February 12, 2013

Project Name: Canal Plaza Hotel
Address: 433 Fore Street
Applicant: Cow Plaza Hotel, LLC, Applicant
Planner: Nell Donaldson

Project ID: 2012-558
CBL: 32-I-40

**NORTH
ELEVATION**

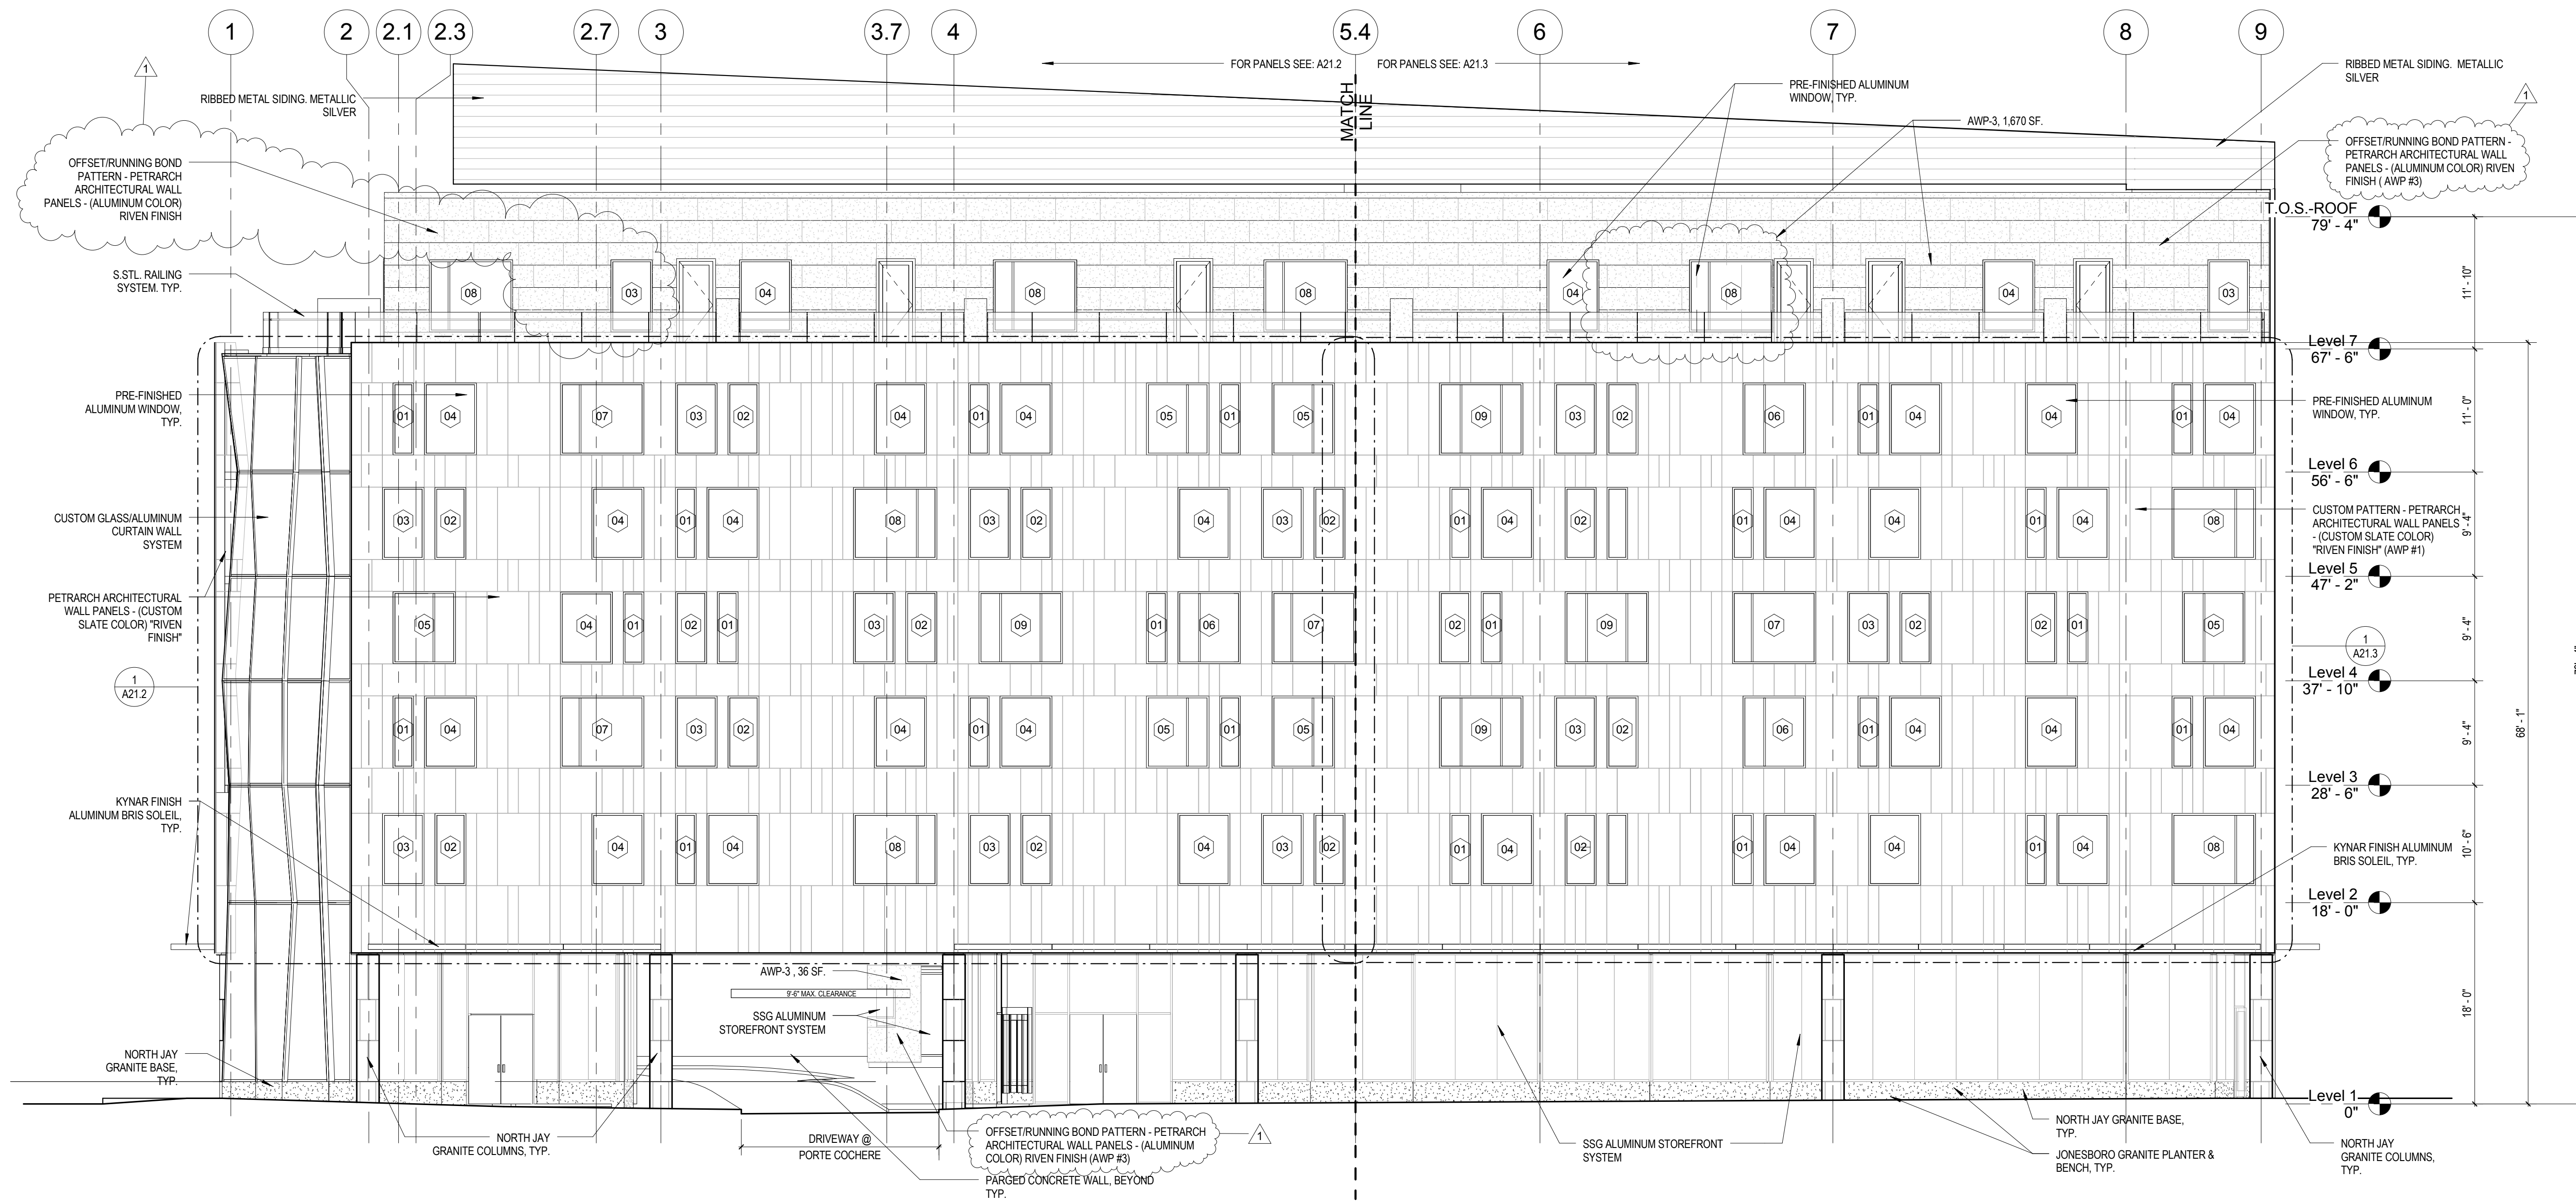
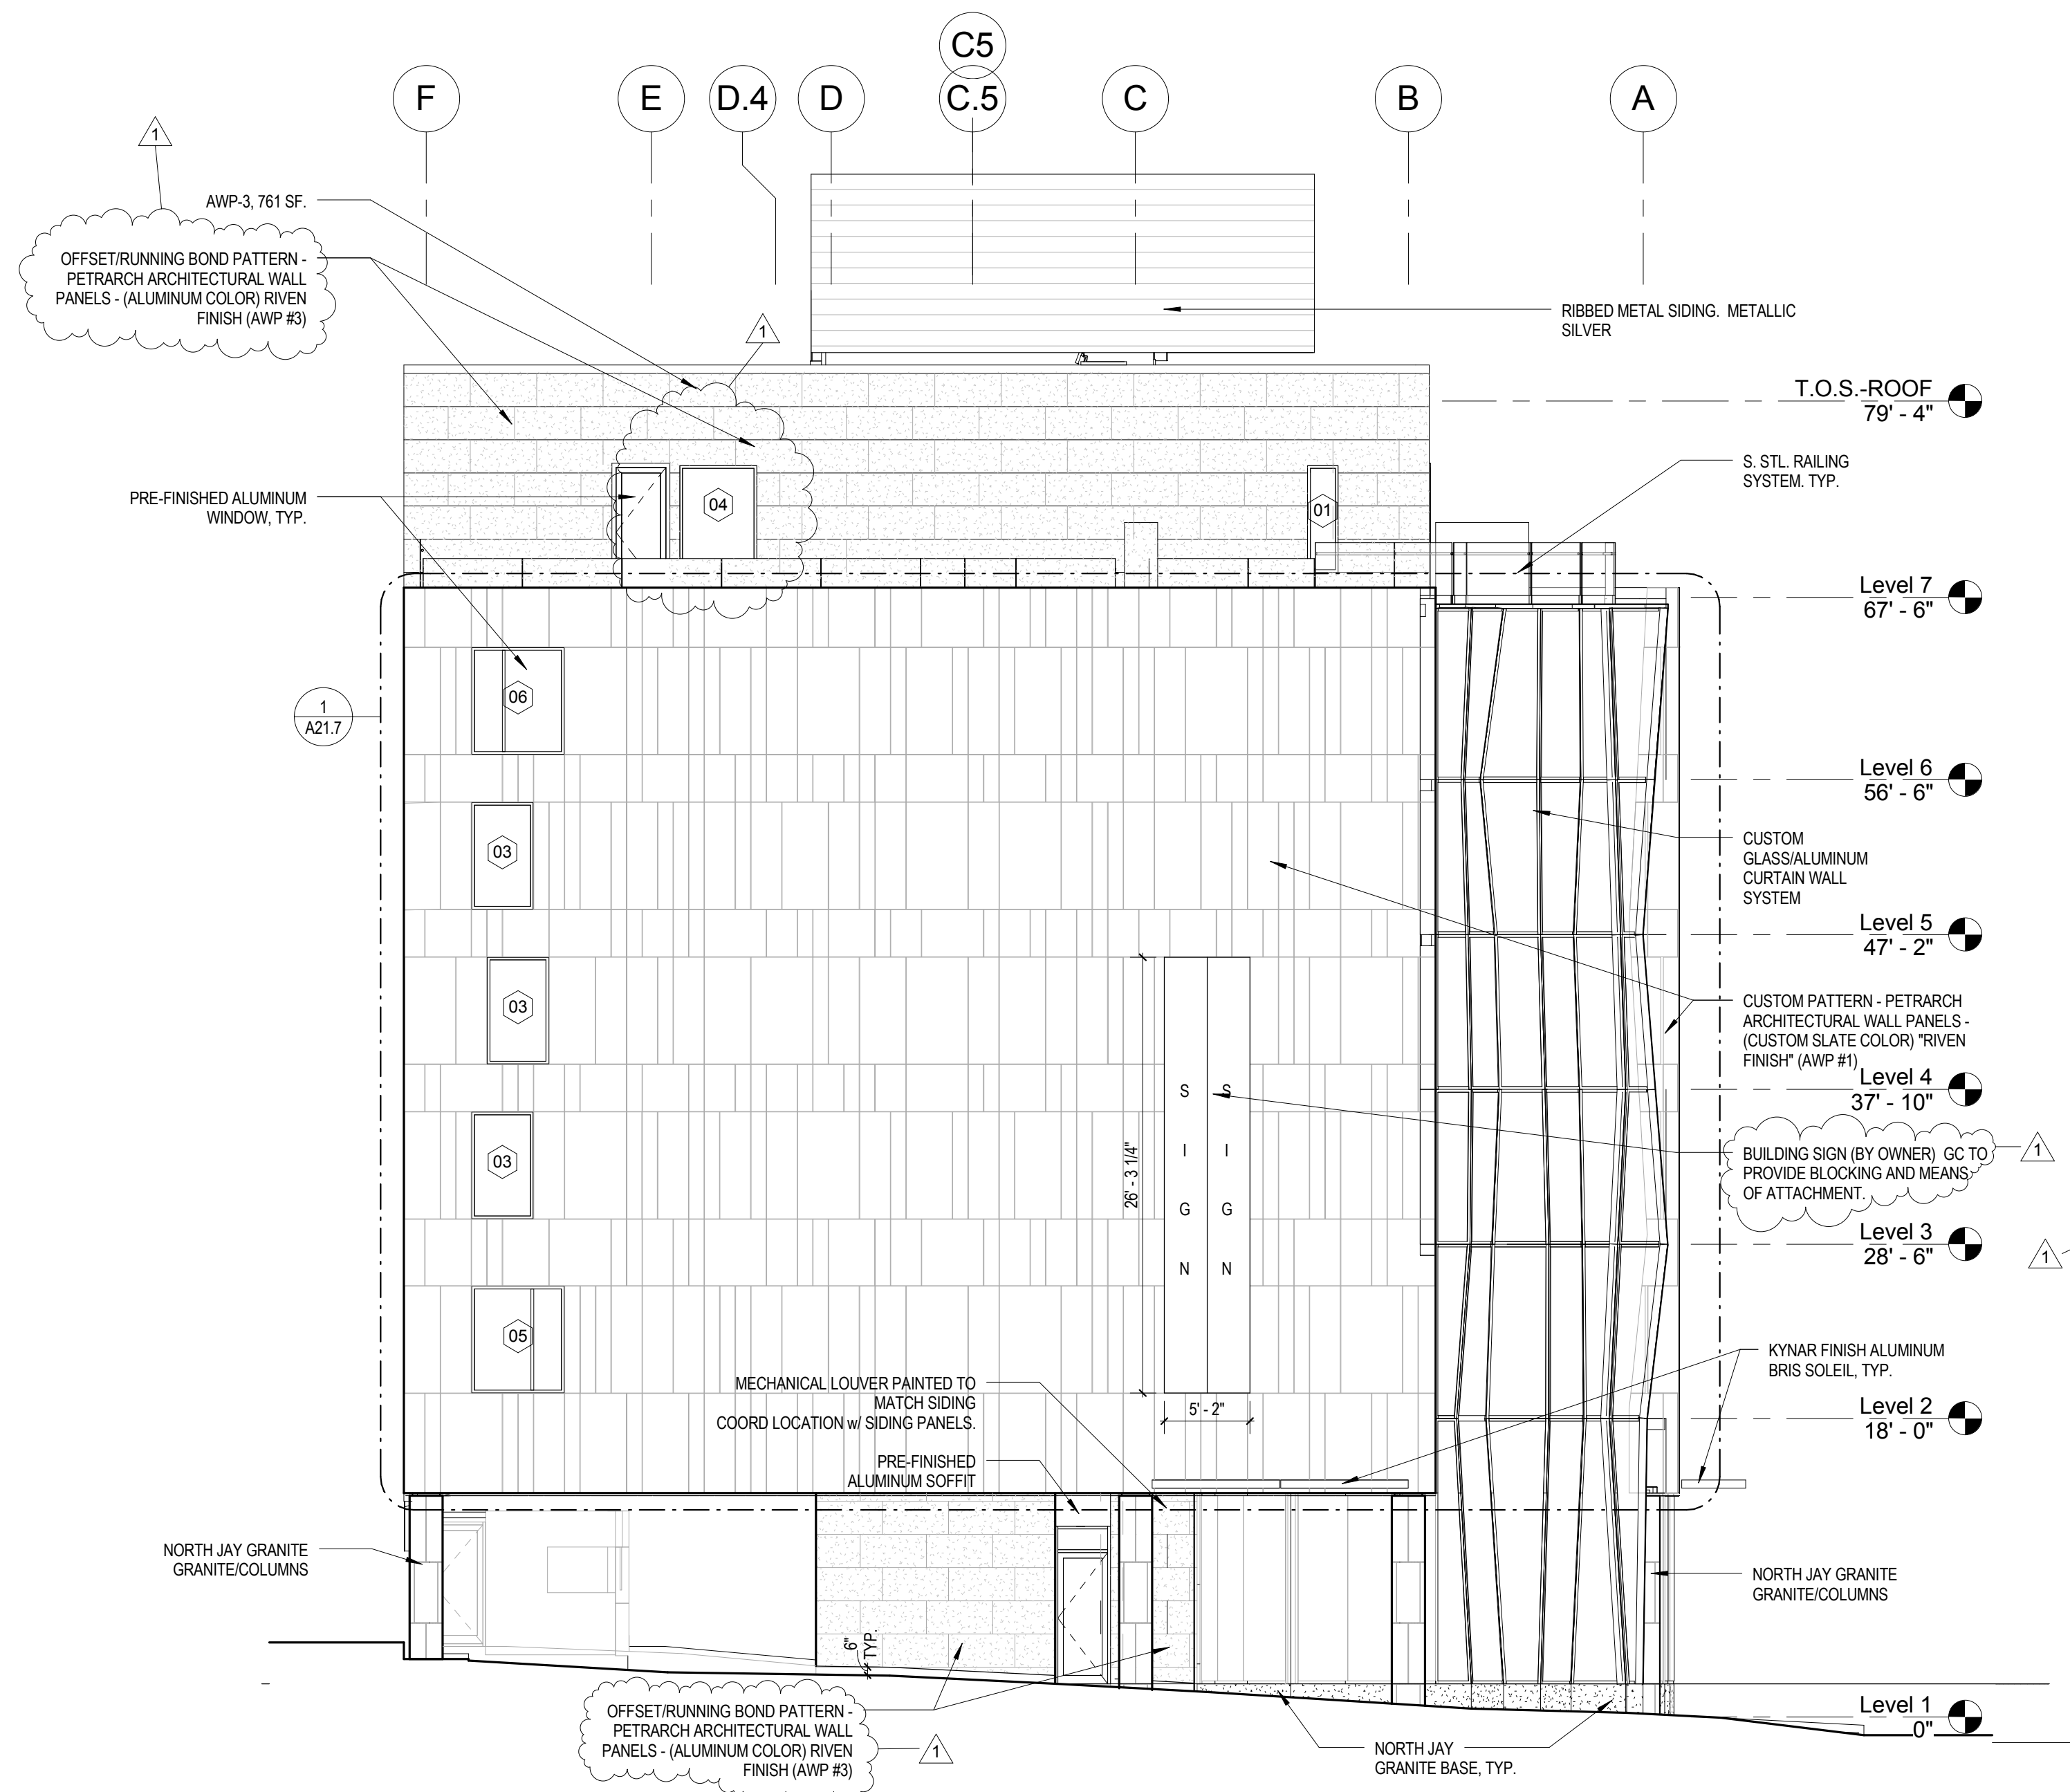
13. The applicant shall submit revised elevations and specifications for the rooftop mechanical screen and stair tower, which address the recommendations of the Planning staff and the Historic Preservation Board, for review and approval by the Planning Authority.
